Our ref: AN/2025/137371/01-L01
Your ref: H12-1156-25
Date: 16 January 2026

**Demolition of barns and erection of self build dwelling
Barns to rear of 60 South Drove**

Environment Agency position

TITLE
PROPOSED FLOOR PLANS & ELEVATIONS

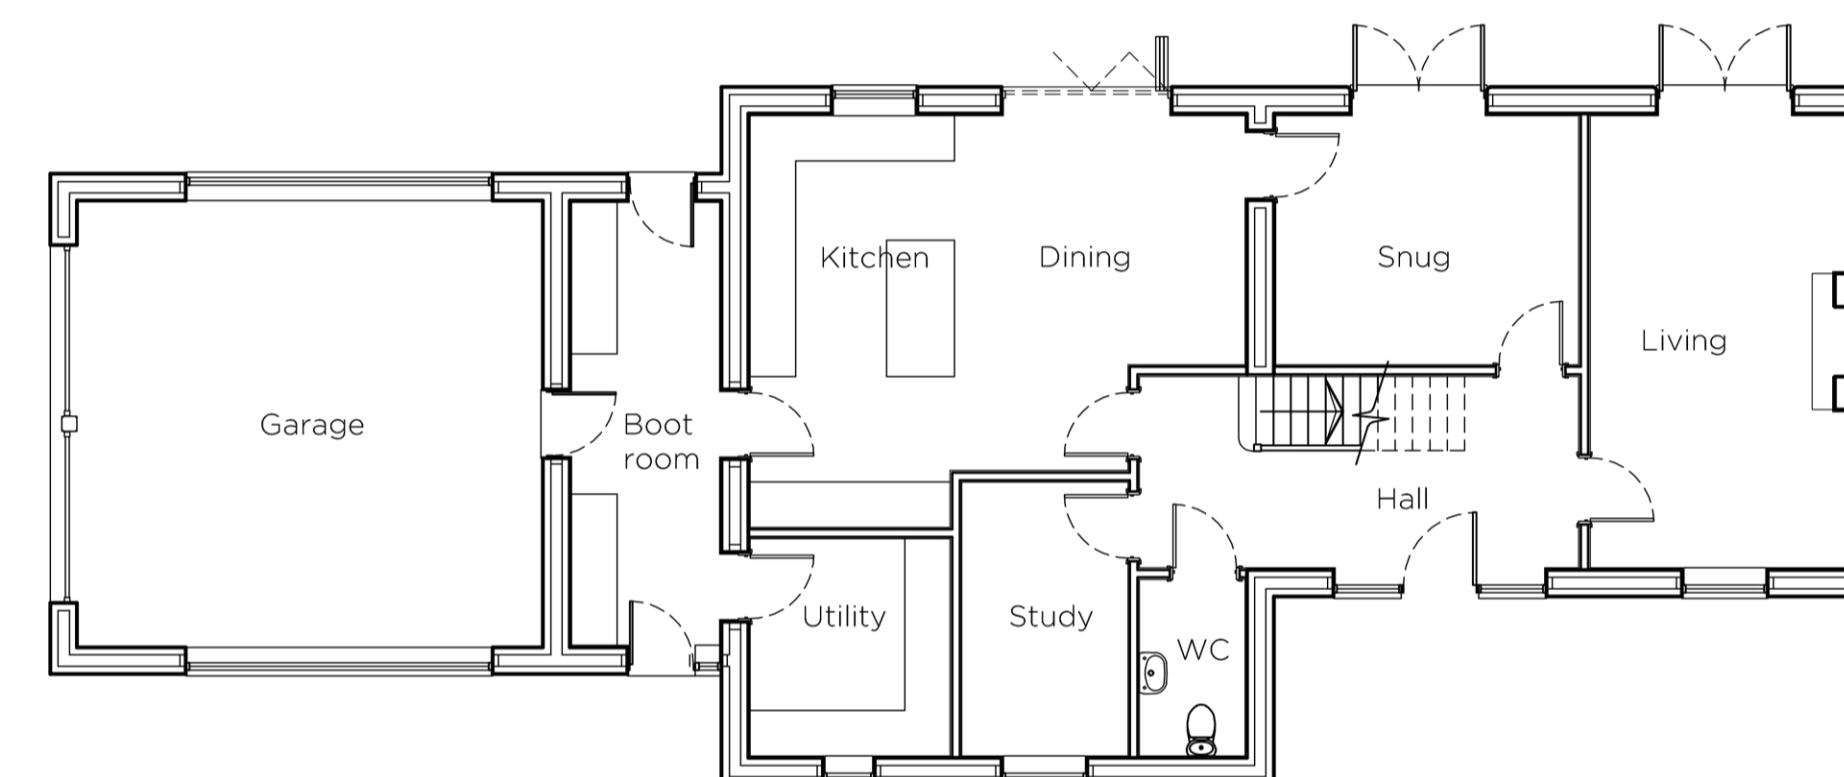
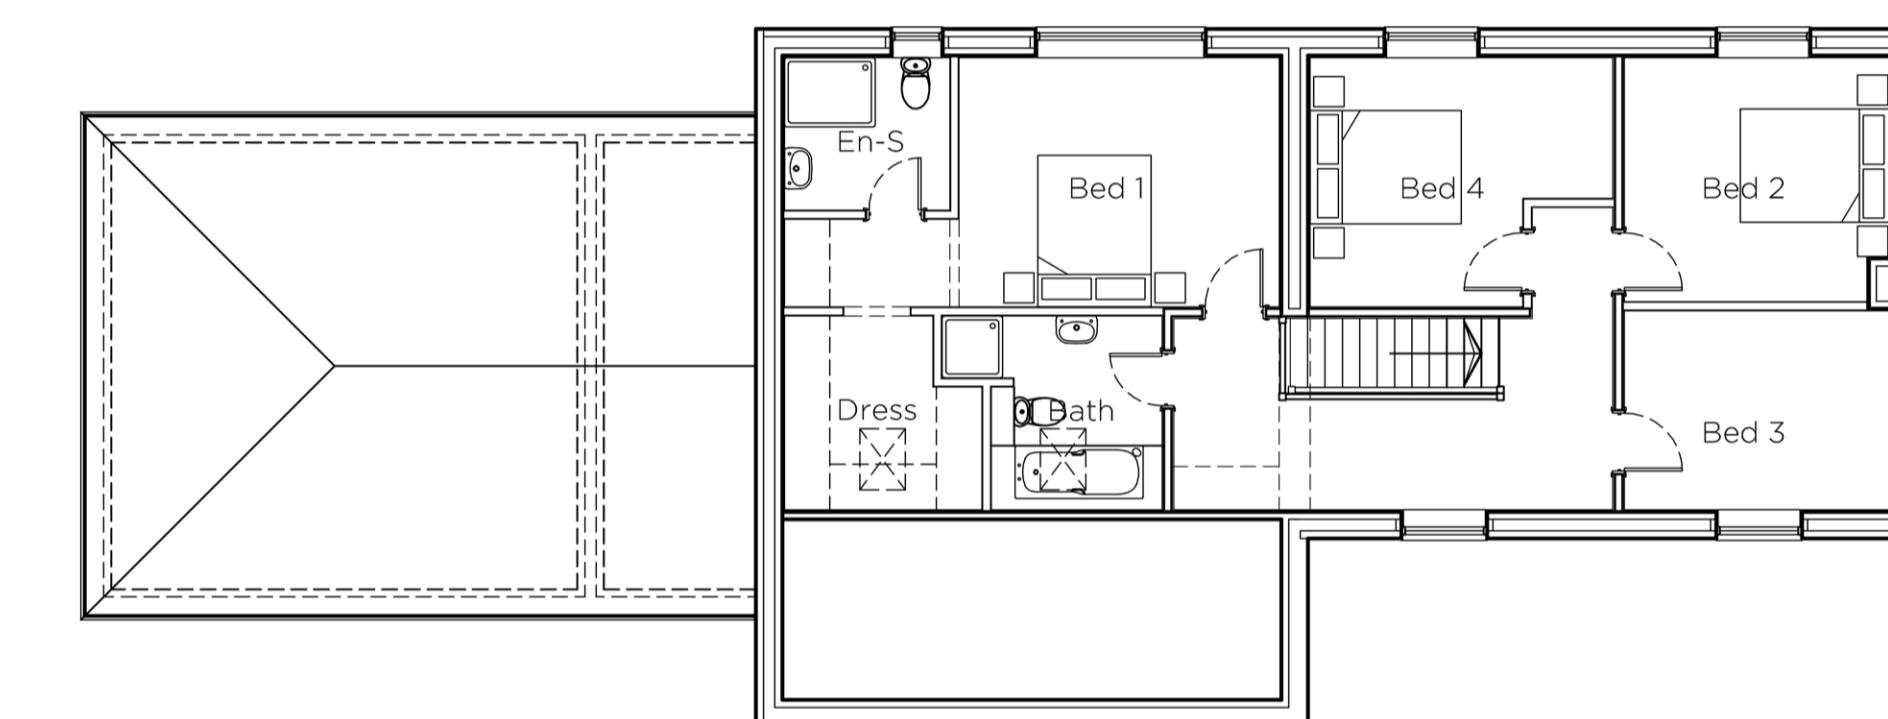
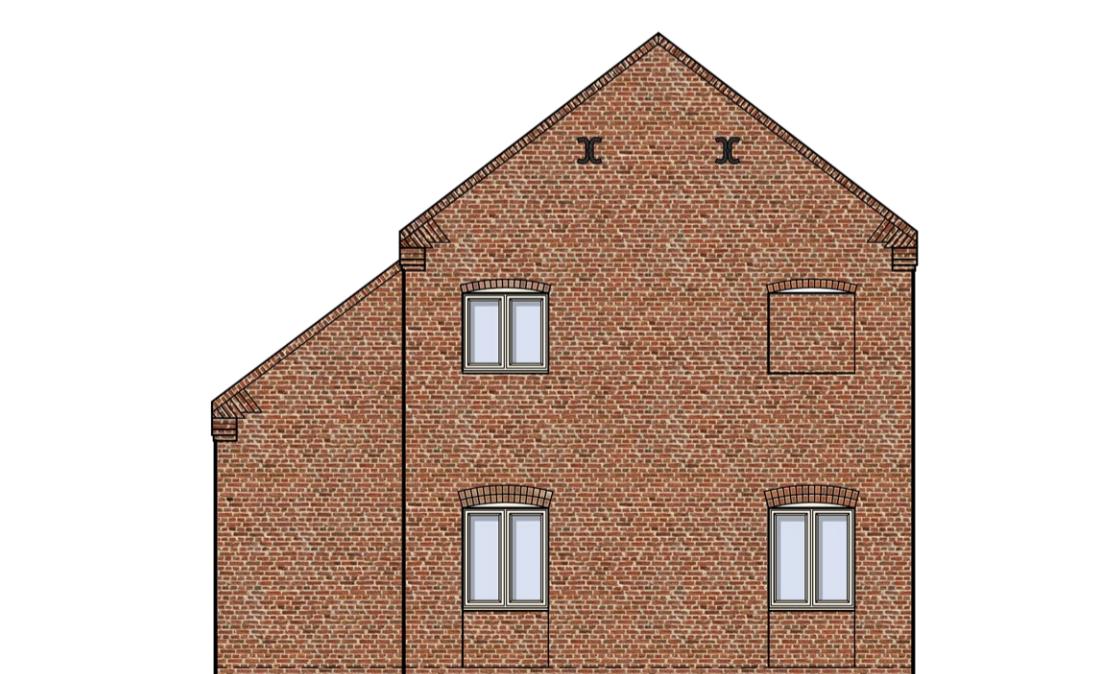
- Finished floor levels shall be set no lower than 1.0 metre above the surrounding ground levels
- The dwelling shall have a minimum 2 storeys
- Demountable defences shall be included to 0.6m above the finished floor level
- Flood resilience measures shall be incorporated to 0.7m above the finished floor level

The submitted flood risk assessment proposes 0.6m of flood resistant construction above the finished floor level but does not explicitly propose the use of demountable defences. The South East Lincolnshire flood risk advice matrix outlines that mitigation should include the use of demountables to 0.6m above the finished floor level for dwellings proposed in areas of flood depths 1-1.6m.

We are therefore satisfied that the proposed development will be acceptable if the 0.6m of flood resistant construction is in the form of demountable defences. Please contact us if you wish to discuss this matter further or if it is not intended to include demountable defences.
